TOWN AND COUNTRY PLANNING ACT 1990 NON MATERIAL AMENDMENT

Reference:	H13-0336-17	Date of Decision:	5th May 2017
Applicant:	Mr David Laidler Larkfleet House Falcon Way Bourne Lincs PE10 0FF		
Location:	3 Shivean Gate Moulton Spalding		
Description:	Proposed two four-bed houses approved under H13-0283-16. Amendments to elevations

Drawing No L158/PLOT 2/06	Rev.
------------------------------	------

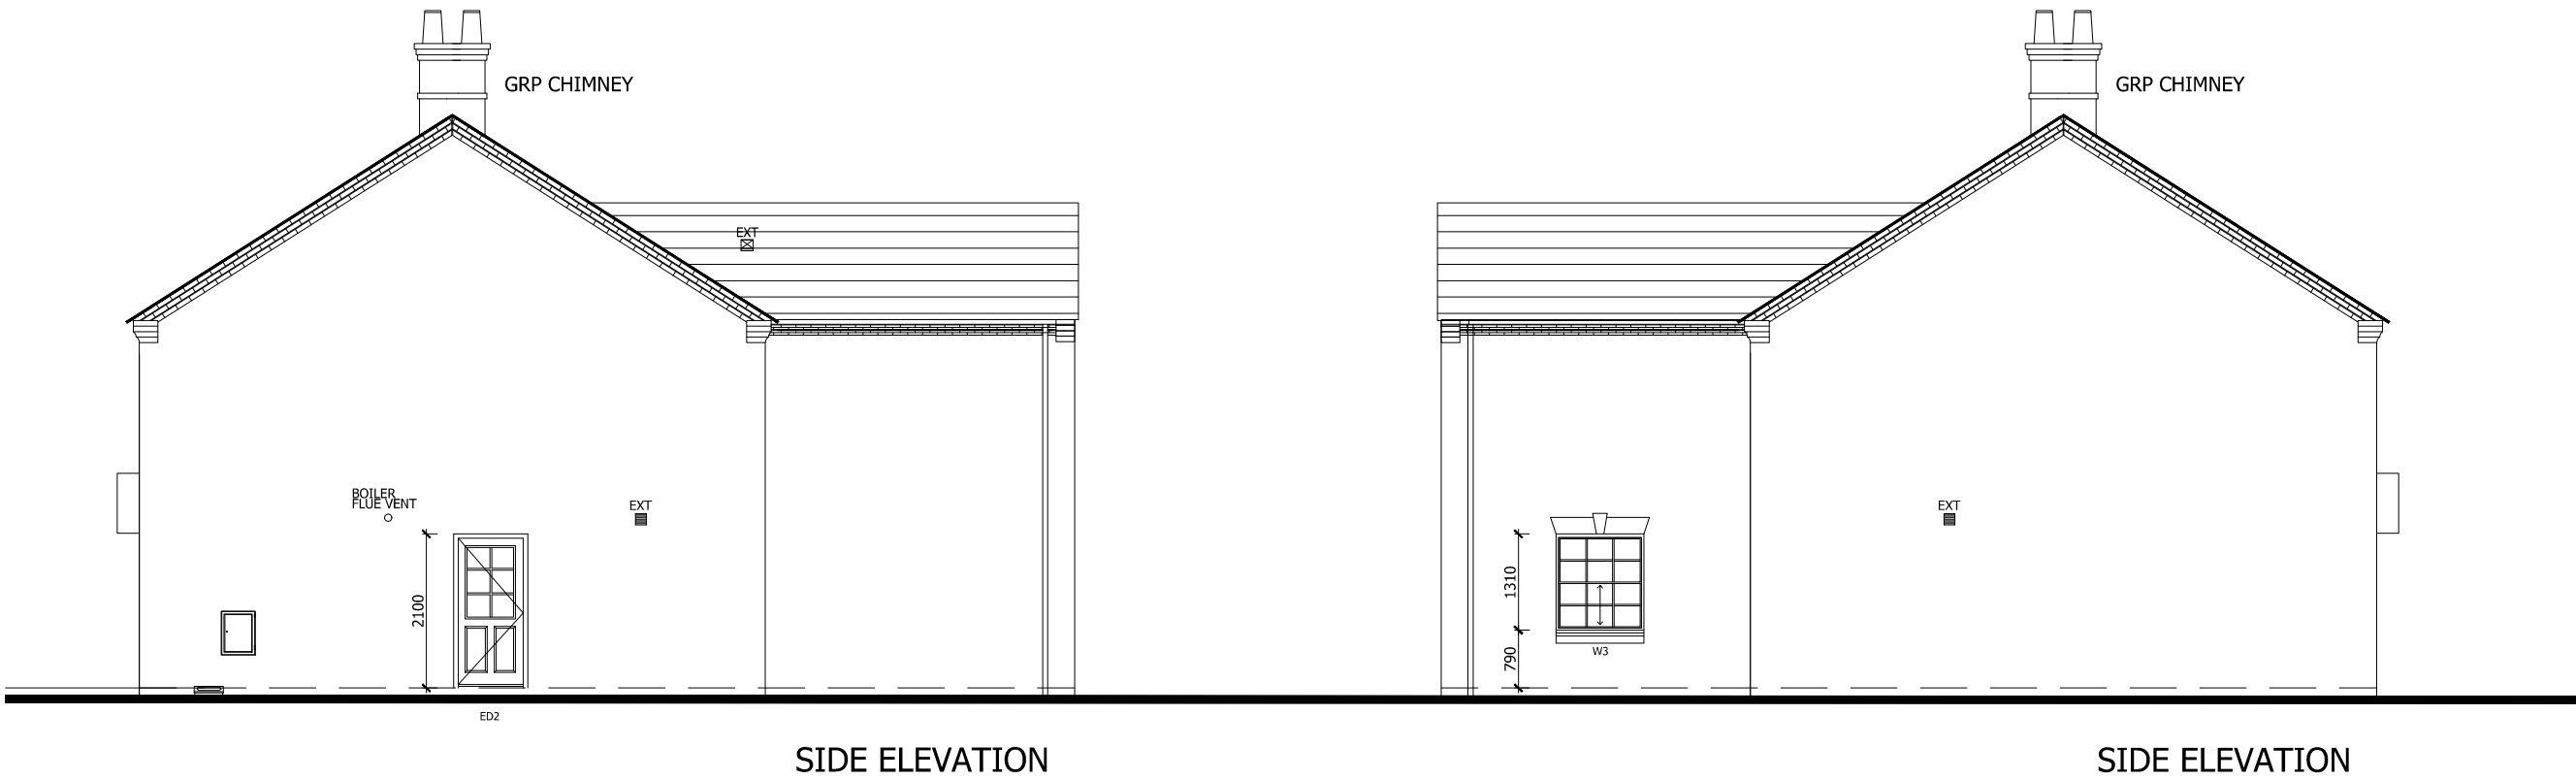
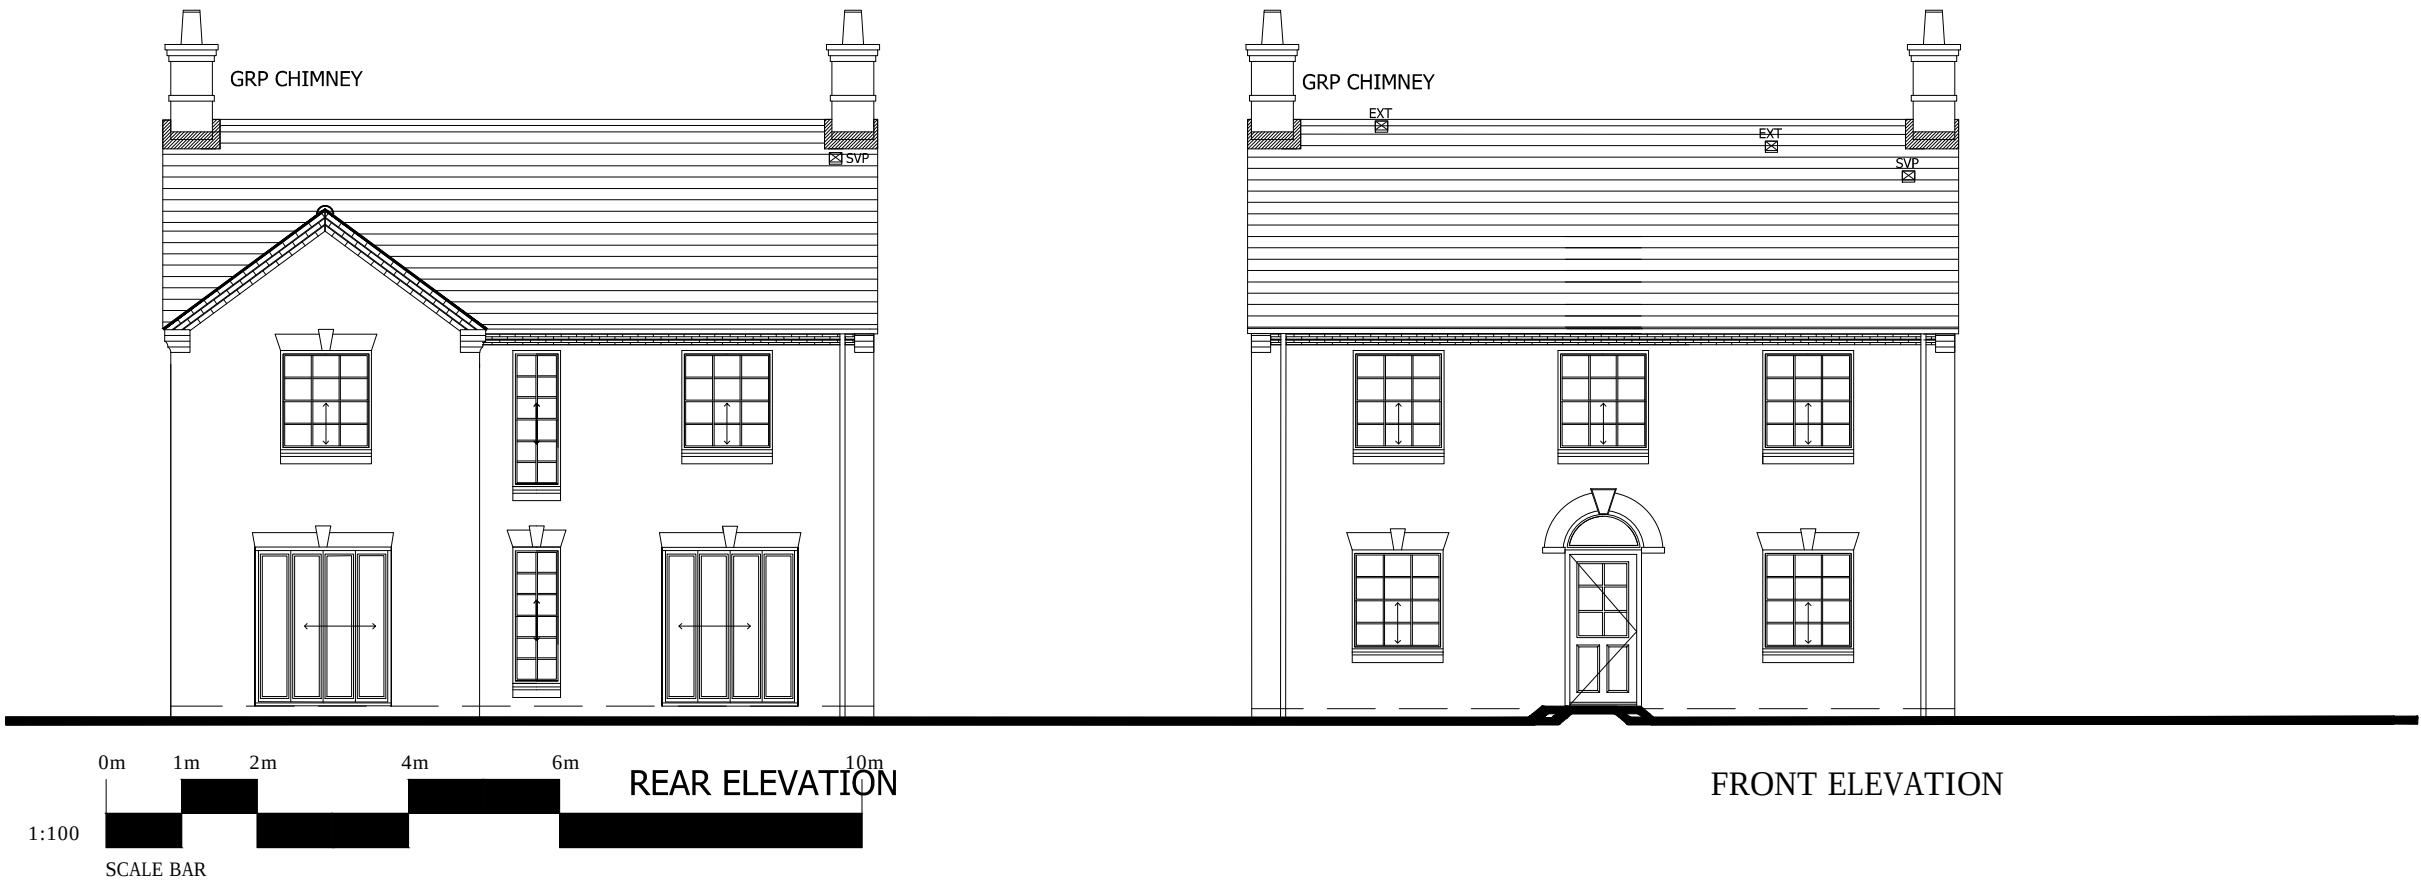
- 1 The alterations to the parapets, windows, doors and chimneys indicated on the submitted drawings are considered to be fundamental changes to the design of the buildings. The proposal cannot therefore be approved as a non-material amendment in accordance with the Authority's Procedure Note on Non-Material Minor Amendments to Planning Permissions.

Whilst omission of the parapets alone may be acceptable as a non-material amendment the revisions to the windows, doors and chimneys indicated on the submitted drawings are considered to be significant design changes that are unacceptable.

The site is located in a sensitive location within Moulton Conservation Area and is in close proximity to listed buildings. Consequently, the design and appearance of front and side elevations of the properties should closely reflect the vernacular and architectural detailing of traditional 19th Century properties within the vicinity of the site.
